Recommendation Report for Planning Permission for Works or Extension to a Dwelling

REF NO: AW/293/20/HH

LOCATION: 8 Hughes Close
Aldwick
PO21 5RU

PROPOSAL: Single storey side and rear extensions.

| TITLE   | Proposed Plans | DRG NO    | IBA/544/03 |

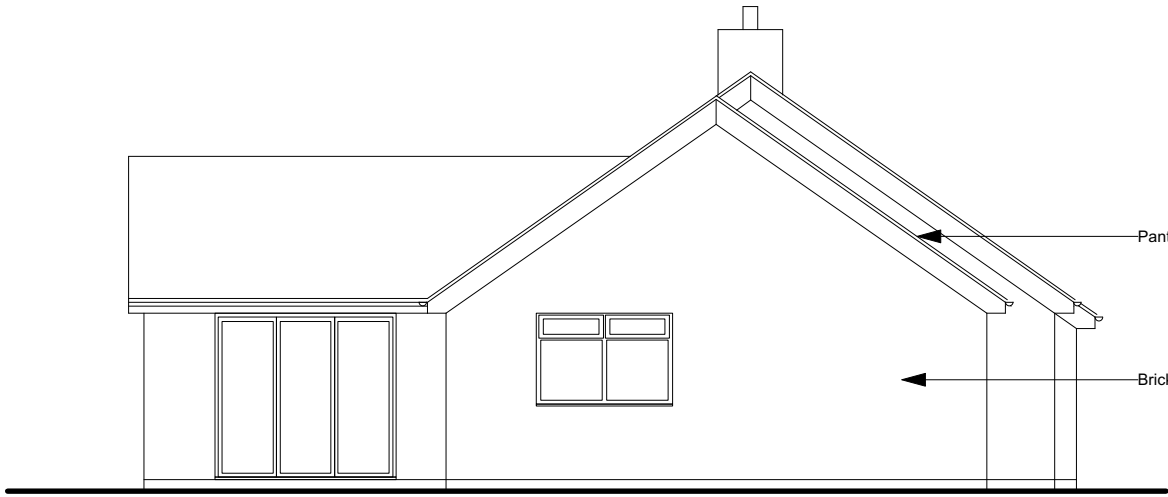
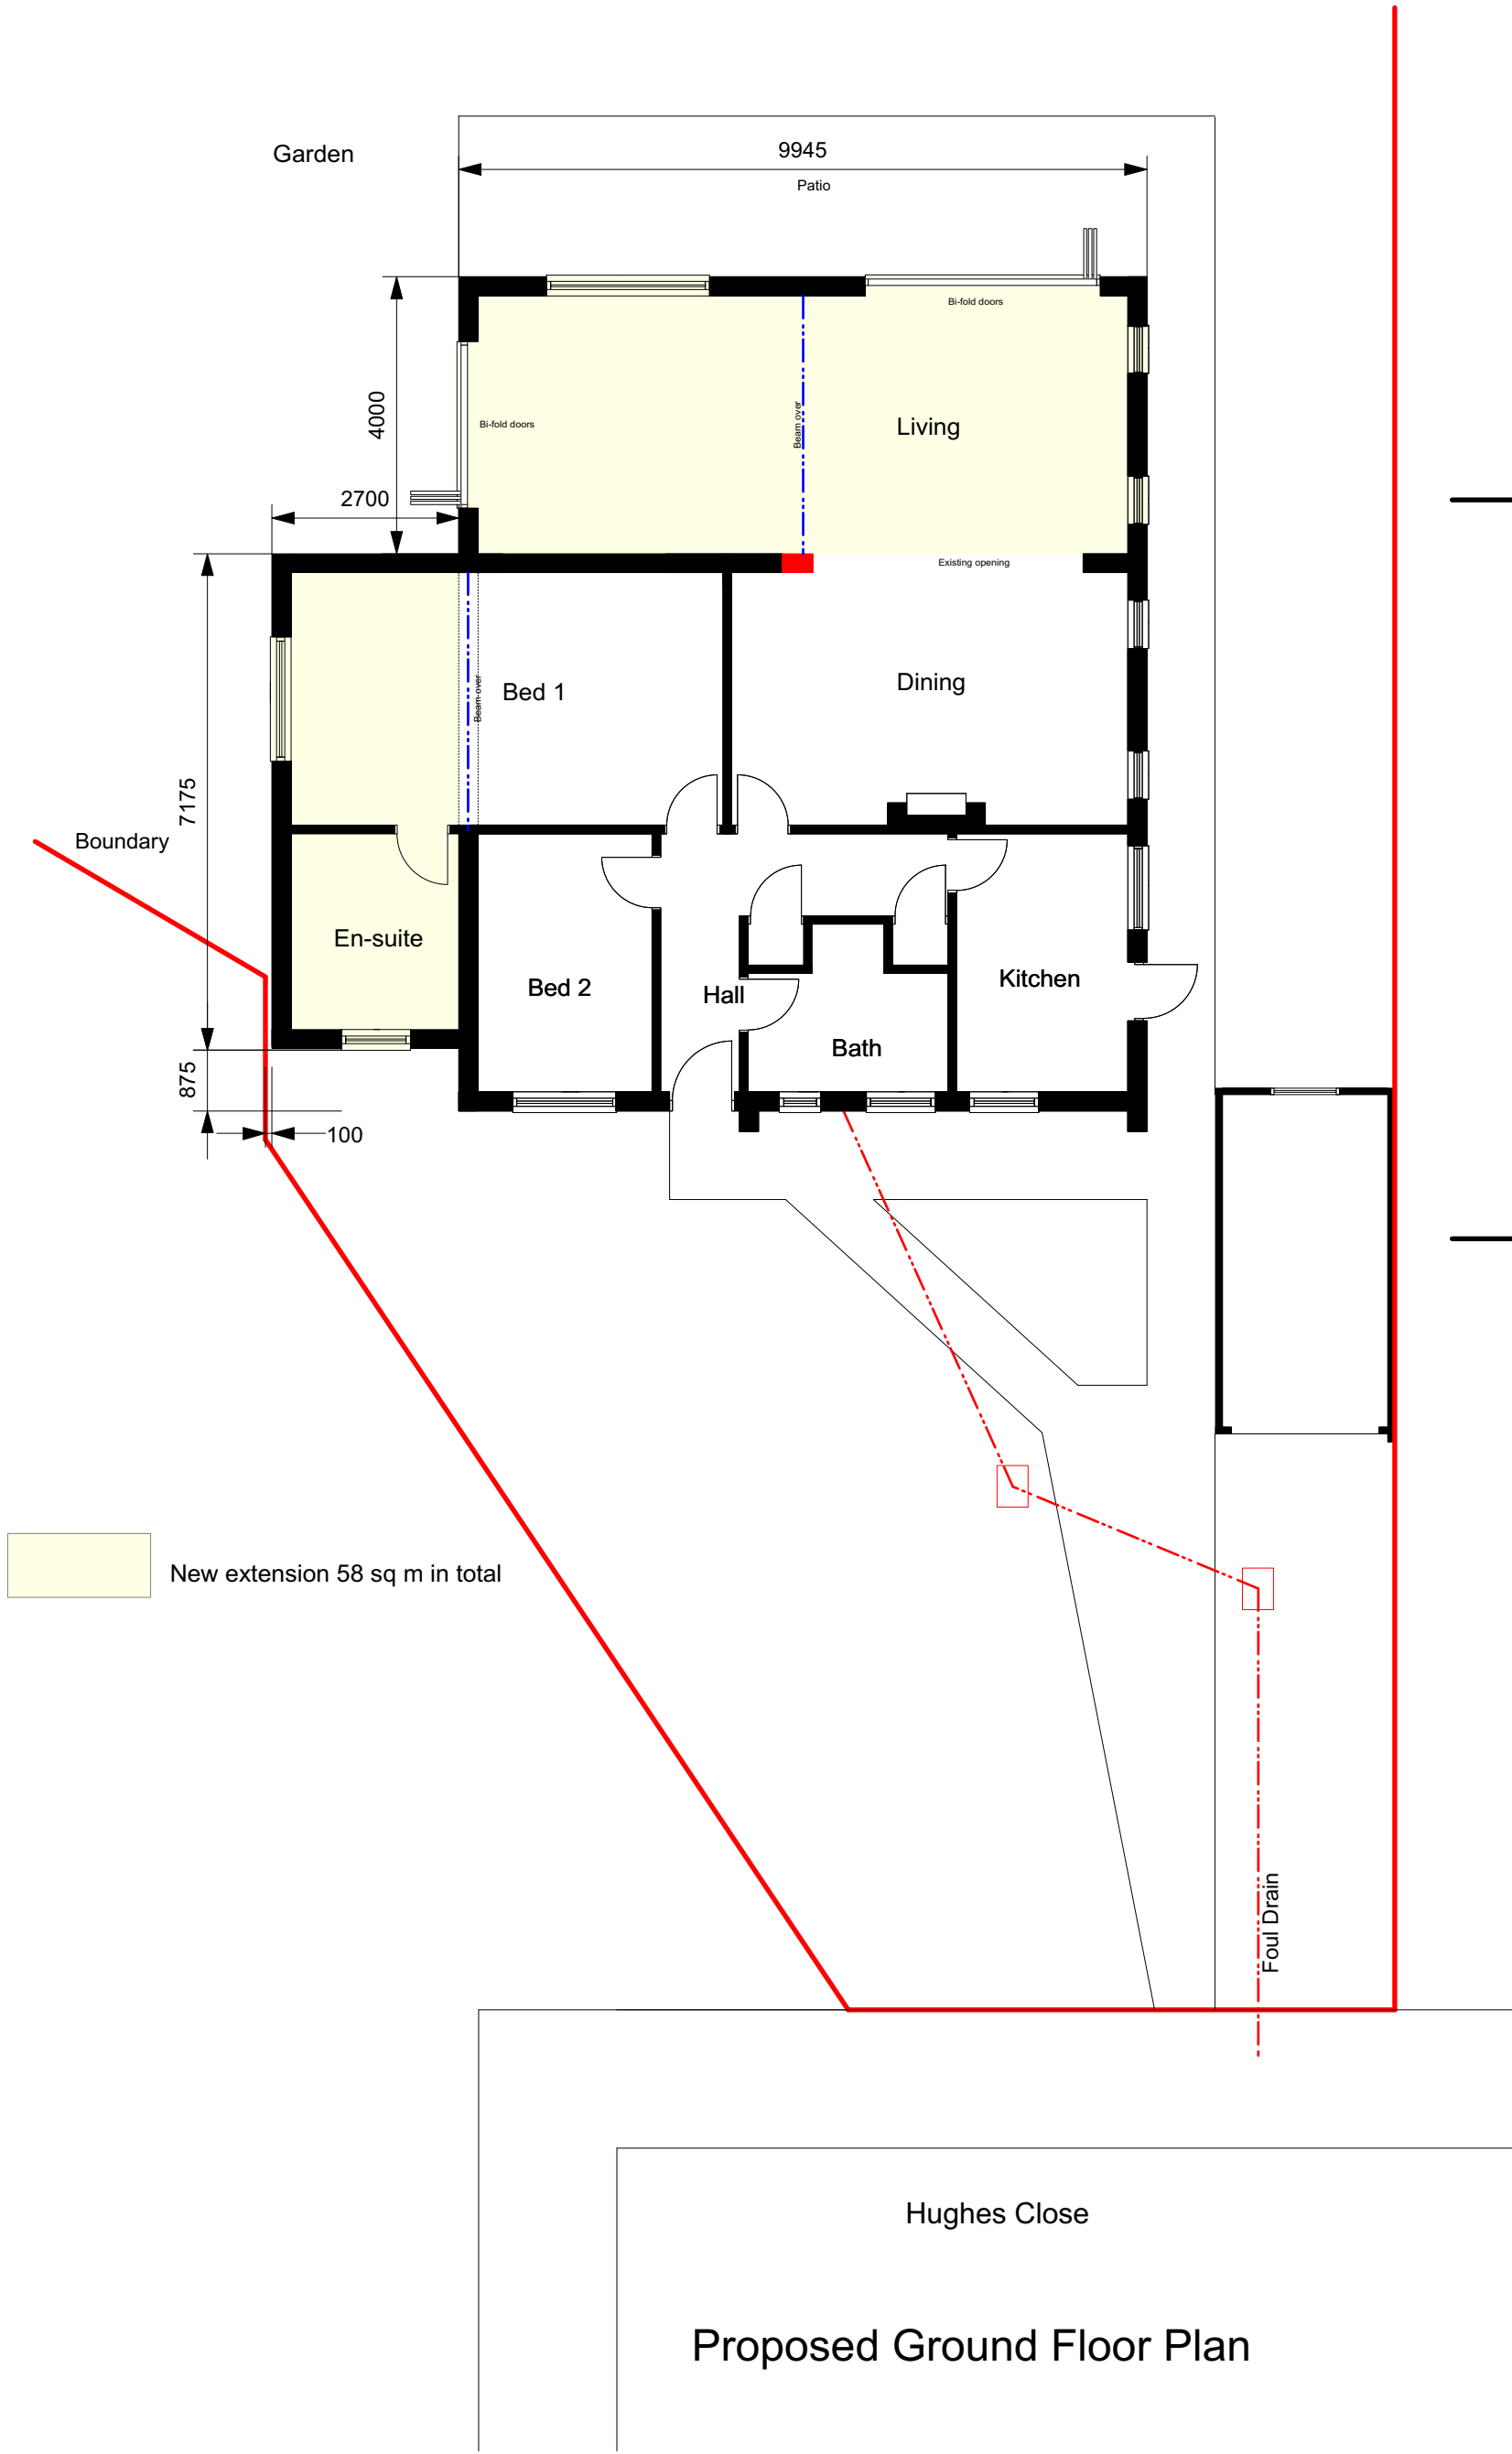
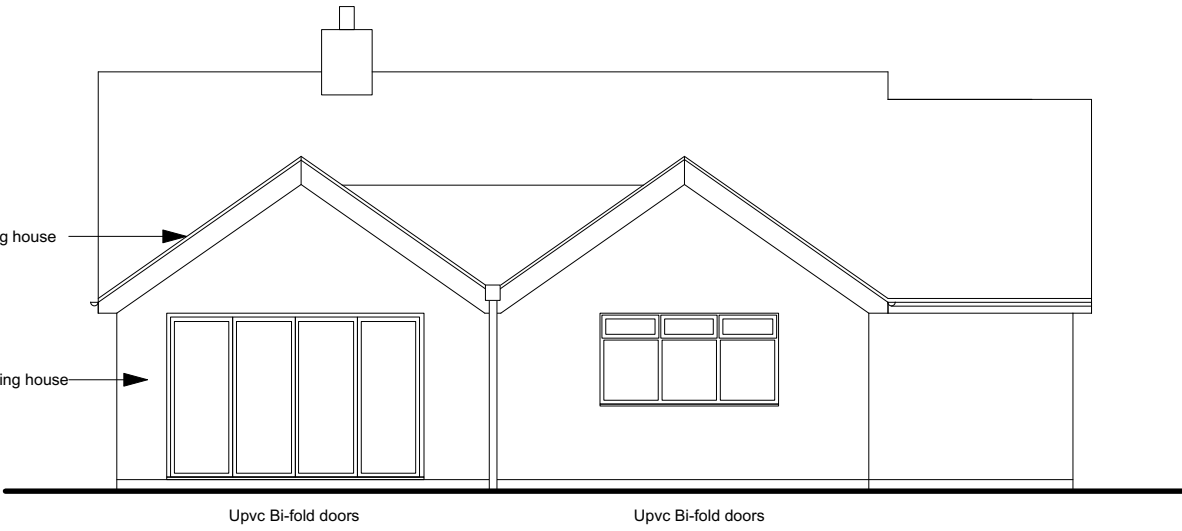
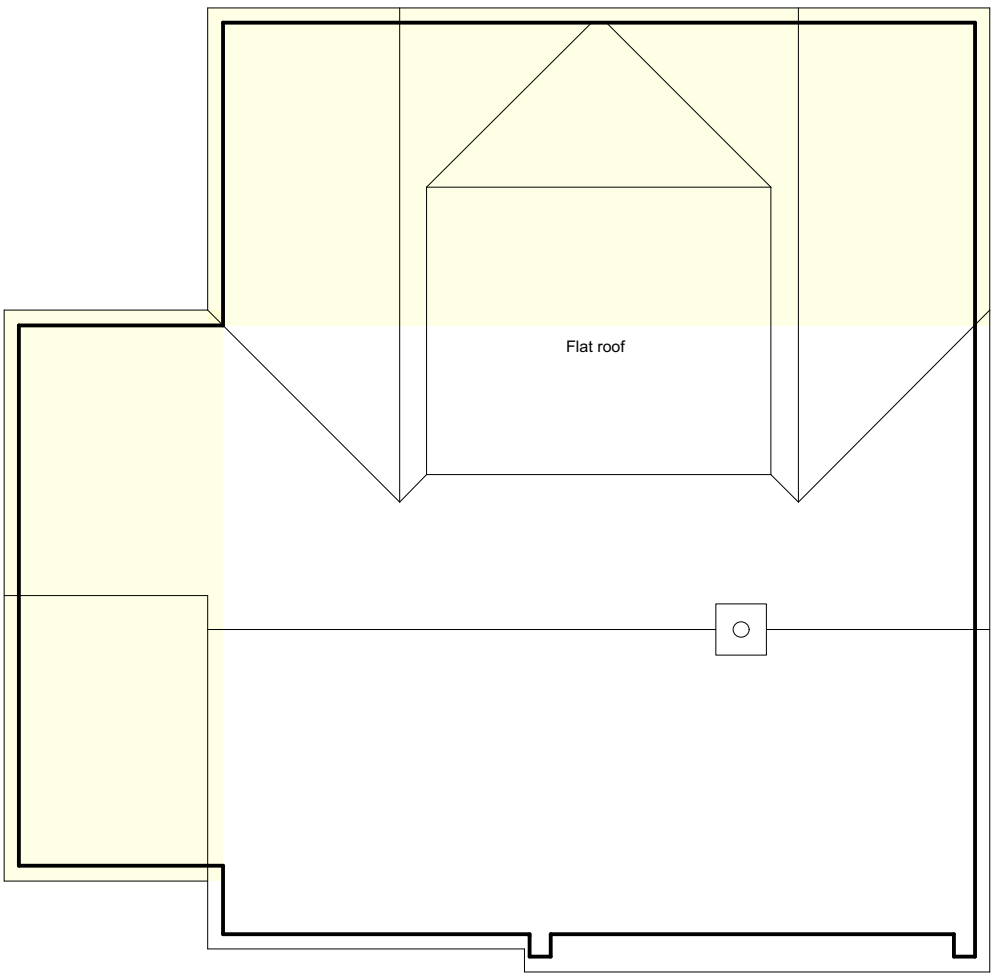
The extensions have been designed to match the existing dwelling in both form, and through the choice of materials, which are similar in nature to those existing. Additionally, the choice of fenestration is thought to match with the host dwelling and as such it accords with policies DDM1, DDM4 and SDP1 of Arun's Local Plan

The proposal is for two, separate, single storey extensions, one to the side measuring 2.7m by 7.17m and one to the rear measuring 9.94m by 4m. The side extension protrudes to the East and has an impact on the street scene being readily visible from the head of the close. This is not thought to cause harm to the view, as this extension will be set back from the front elevation by 0.87m and have a ridge line lower than the host dwelling and an eaves line to match, as such it is thought to be subservient to the host dwelling. The rear extension is also constructed in such a way, with 2 dual pitch roof sections, that its ridgelines are also lower than the host dwelling, with eaves to match, and therefore also accord with policies DDM1 and DDM4 of Arun's Local Plan.

The side extension is to be built hard up against the boundary with No 10. Due to the site's positioning at approximately 45 degrees with No 10 and the boundary line not being parallel with either building, it this will not cause any undue overshadowing or overbearing harm. The rear extension will have most impact on the neighbours at No. 9. As the extension is approximately 3.6m from the boundary it is not anticipated that this will cause any demonstrable harm to the occupants; as such it is not thought to be overbearing or overshadow its closest neighbours.

Customarily the dwelling has had fenestration to its front and rear elevations only. The proposal has introduced a set of bifold doors and a new bedroom window to the side elevation facing No. 10. These windows are at ground floor and would not be expected to gain views of the neighbouring property that are not already visible, the same can be said of other fenestration in the scheme, comprising a small en-suite window facing the front and another set of bifold doors and window facing the back garden. The extension accords with policies SPD1, DDM1 and DDM4 of Arun's Local Plan.
